**From:** Bloomer, David <David.Bloomer@lancashire.gov.uk>  
**Sent:** 31 August 2018 09:12  
**To:** Stephen Kilmartin  
**Cc:** LHS Customer Service; planning  
**Subject:** app3/2018/0701 55 Derby Road, Longridge

There are a number of issues that would need to be clarified / resolved regarding this application

Proposed Block Plan

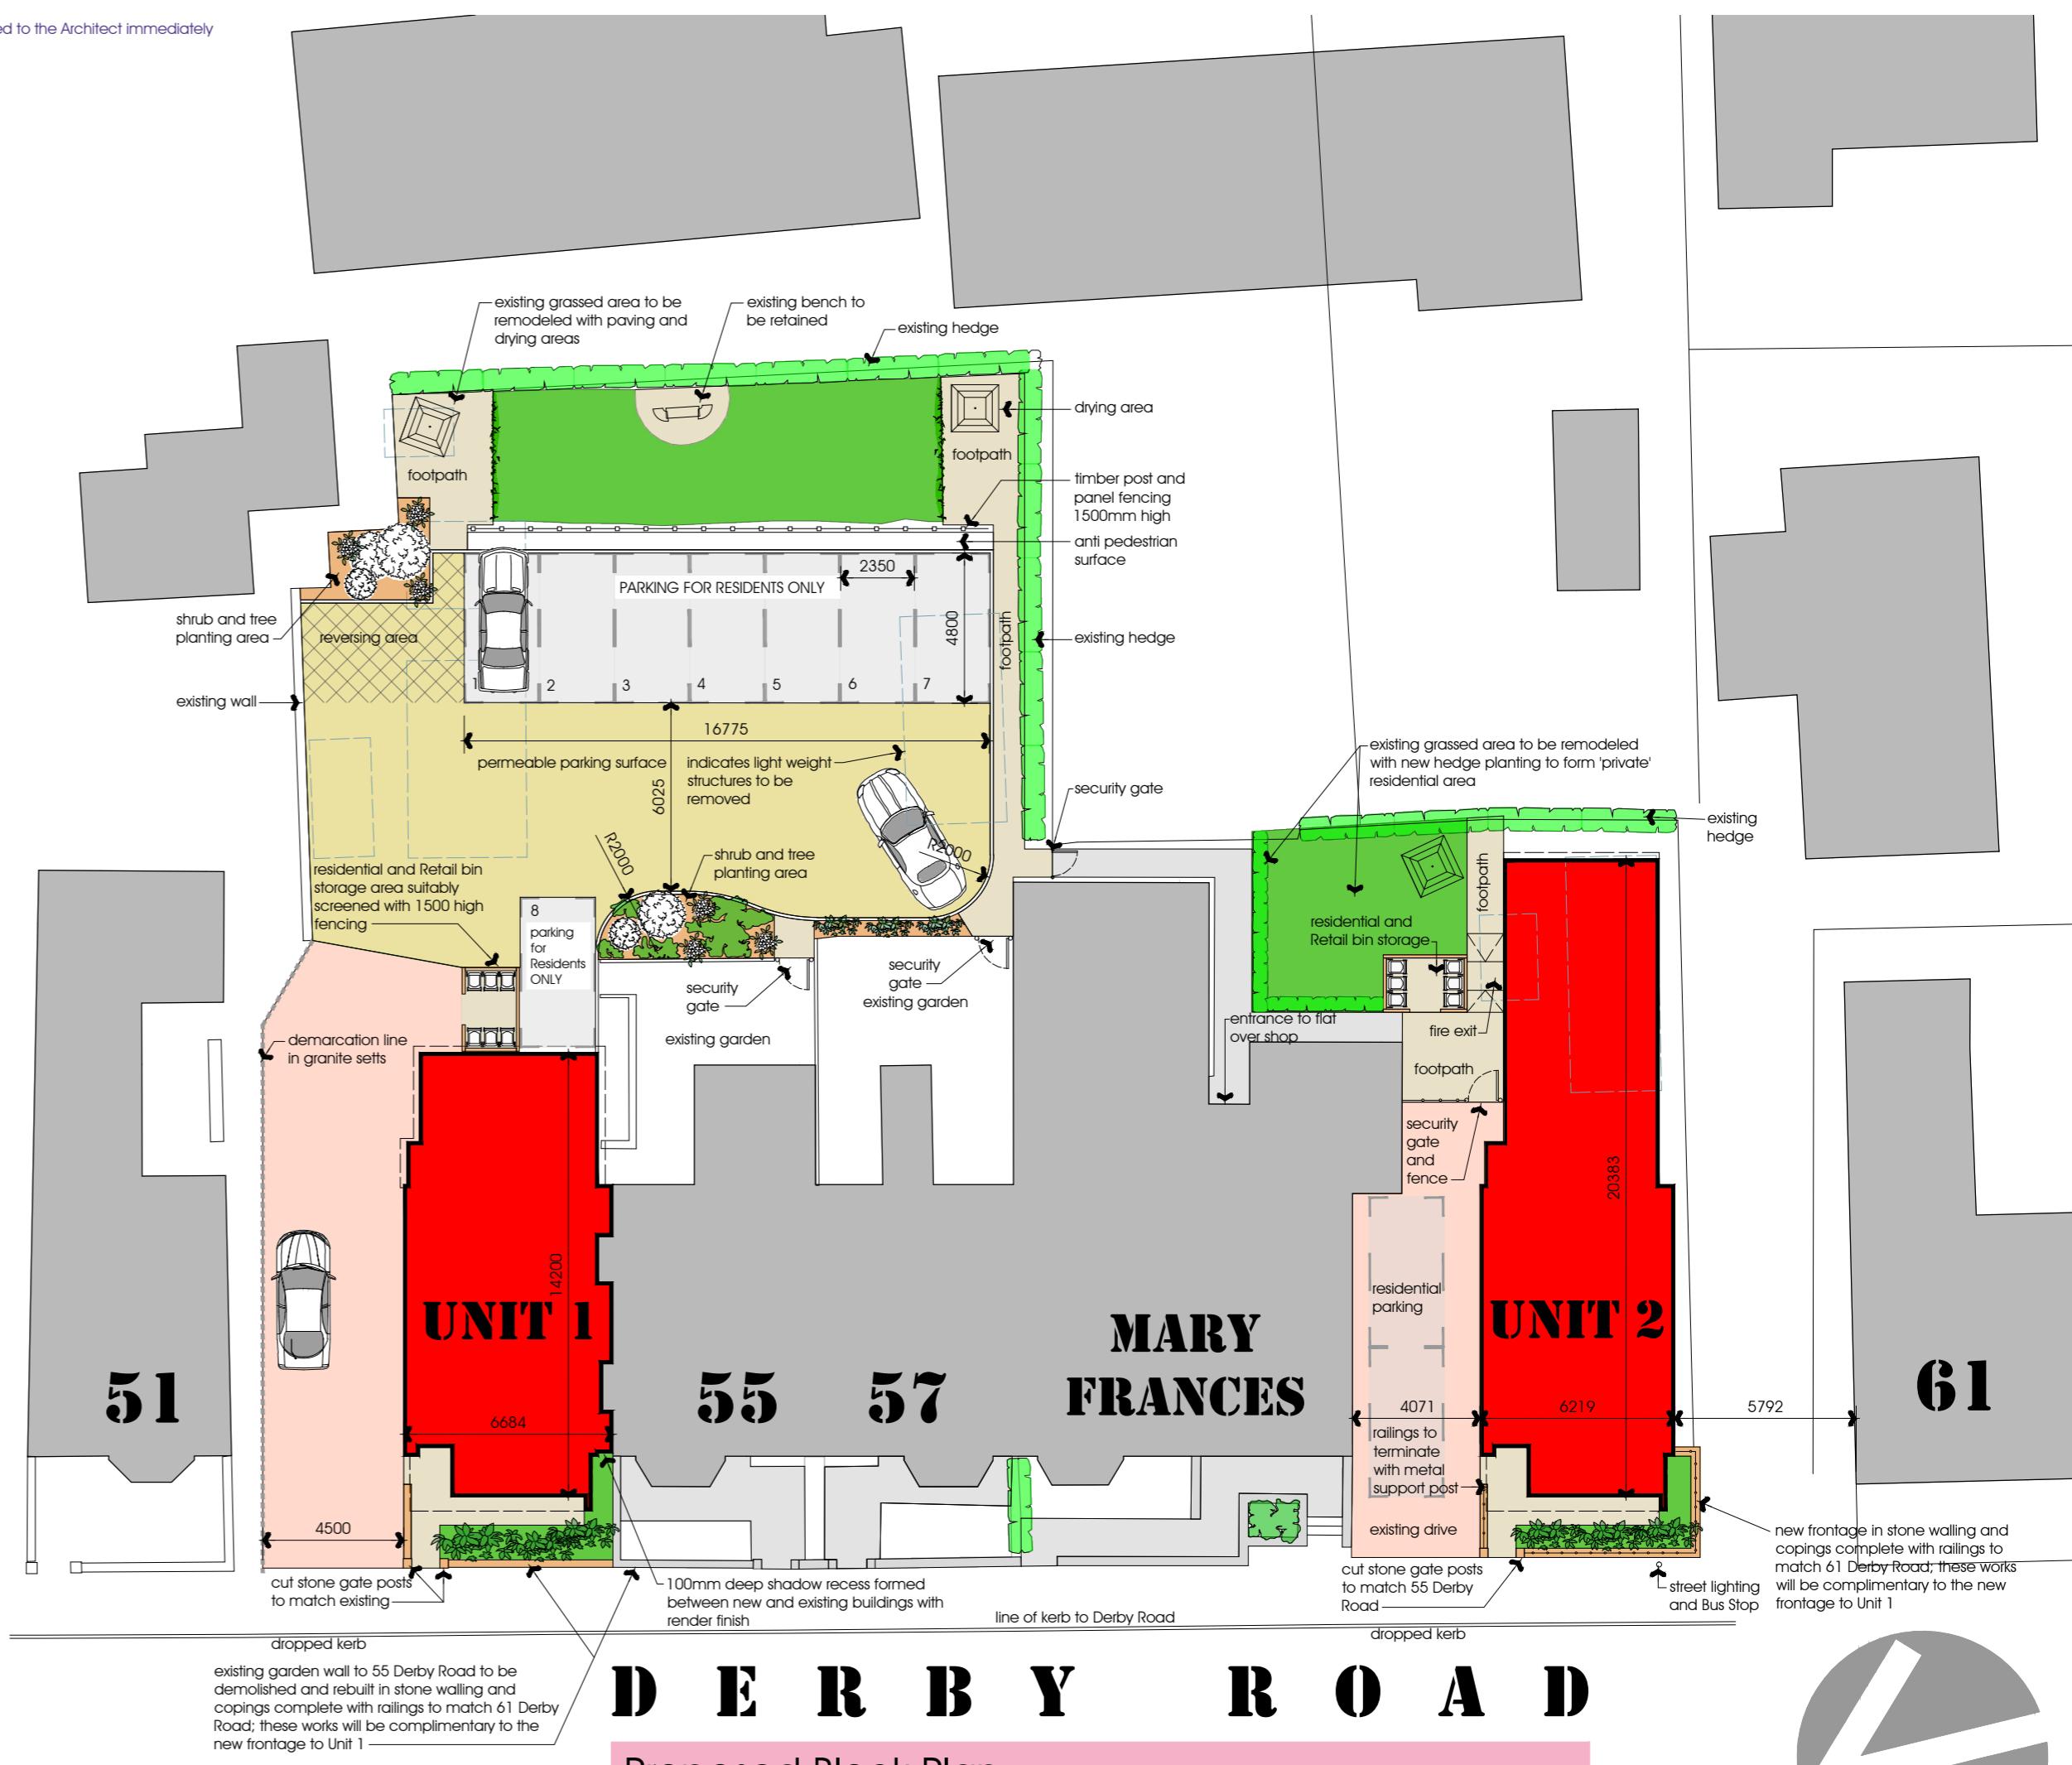
1 The residential element of the proposal would attract a parking provision of 4 spaces with the retail element requiring a further 8. Only 8 parking spaces have been provided (+ the 2 spaces retained to the side of Mary Frances)

2 The parking provision for Nos 55 and 57 have not been shown. It is assumed that they currently enjoy parking facilities to the rear. In order to ascertain these requirements I would need to know the number of bedrooms in each property. Similarly are there any residential flats above the Mary Frances shop?

3 What is the parking provision for No. 51? Do they have access to the rear? Is the access under shared ownership in which case can the resident of No. 51 legitimately park on the access.

Parking in this area is likely to be at a premium and the existing shop had a steady stream of customers during my visit. There is also a bus stop outside Unit 2 and access to this will need to be protected, further restricting the availability of on-street parking.
